5 February 2026

***Mingara Recreation Club Seniors Housing, Tumbi Umbi (SSD-63475709) – Council Submission***

Council raises the following outstanding concerns in relation to the amendments undertaken by the applicant regarding the proposed development:

WATER INFRASTRUCTURE

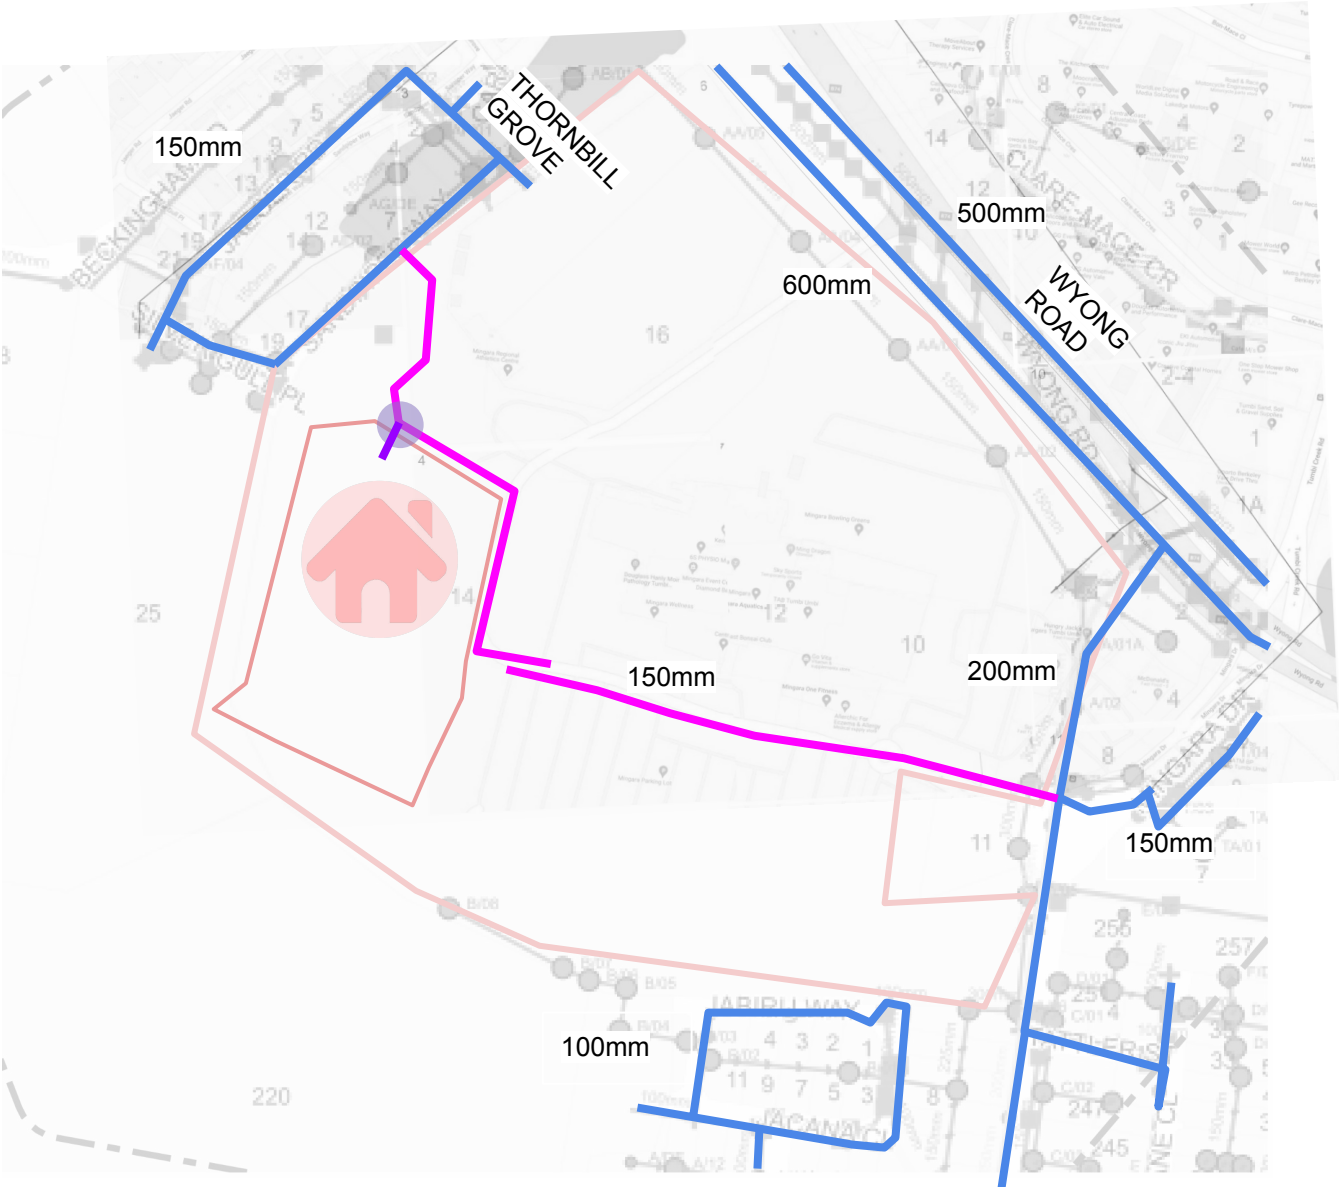
- For water servicing, the proposed development will be required to connect to the existing water main along Silver Gull Place due to the proposed height is greater than 4 storey (but less than 8). Pipe works beyond Council water meter will be considered as private plumbing and will need to comply with AS3500 and inspected by Council plumbing and drainage team. Applicant can apply for the new water service on Council website via Property Application Portal.

Figure 3-1. Riparian restoration plan

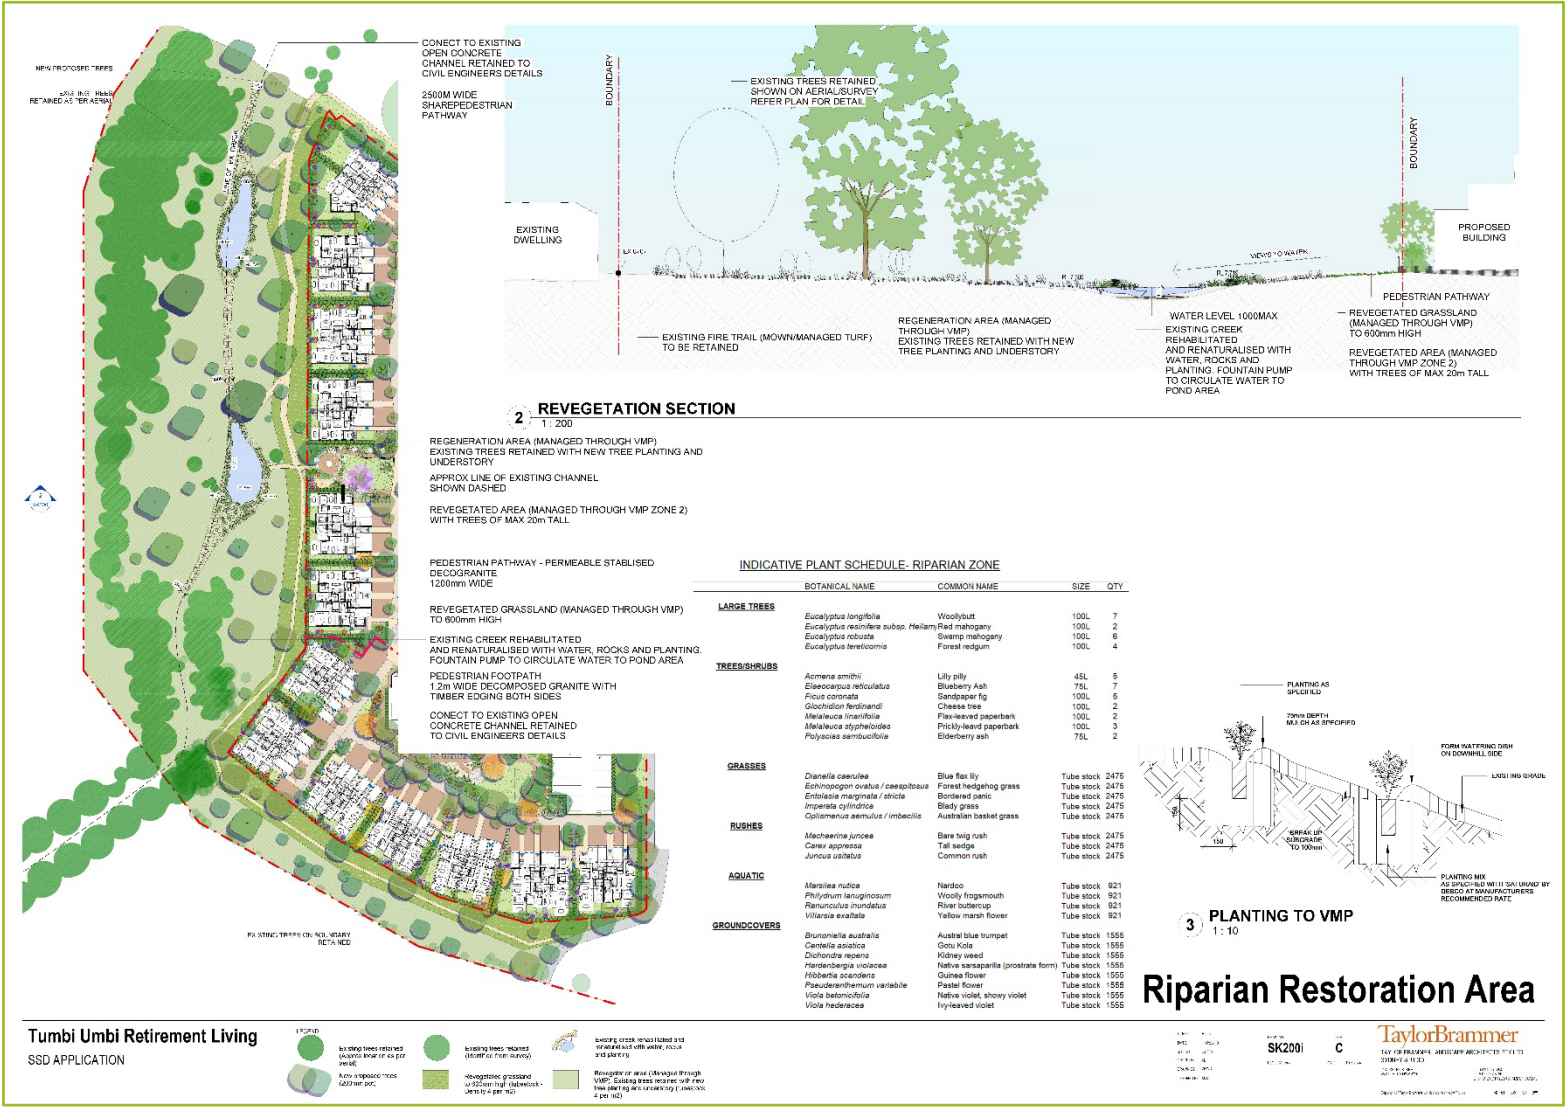
Council advise that several key elements of the Vegetation Management Plan (VMP) have not been resolved in the amendment.

The applicant's amendments to the VMP do not satisfy the ecological intent or technical restoration requirements outlined in Council's earlier submission.

The following issues remain with VMP:

- The VMP is framed incorrectly as voluntary landscaping rather than an ecological mitigation measure to alleviate the direct and indirect impacts to biodiversity resulting from the SSD
- The VMP does not meet a 5-year maintenance period,
- The VMP does not adopt SMART principles or multi-phase staging,
- The VMP offers insufficient detail on local provenance planting, planting densities and weed management, and

- The VMP minimises opportunities for community education.

As a result, the VMP in its current form does not meet Council's Flora and Fauna Guidelines nor does it demonstrate best-practice standards for riparian ecological restoration associated with a State Significant Development.

Given these deficiencies, Council recommends that the VMP be revised and conditioned as a mandatory, enforceable, ecological management document, including a 5-year maintenance period, along with the recommendations outlined in Council's previous submission.

Figure 13: Proposed Sewer Drainage Connection Point

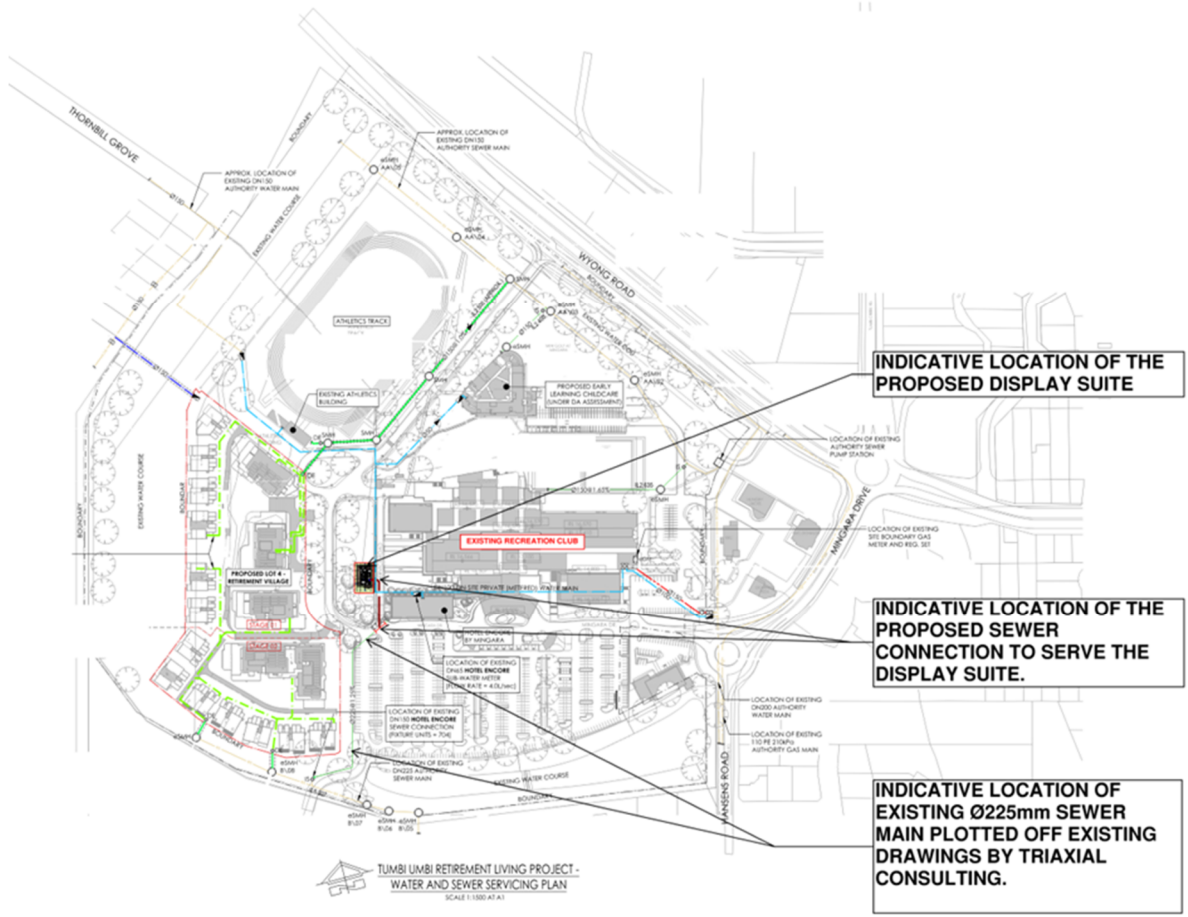
- The “appendix R updated sewer servicing plan” indicates a sewer main extension from existing 225 mm gravity sewer main along Wyong Rd. Please note that the whole development (both stage 1 & 2) will be required to connect to this sewer and it is applicant’s responsibility to ensure the proposed development is designed accordingly.
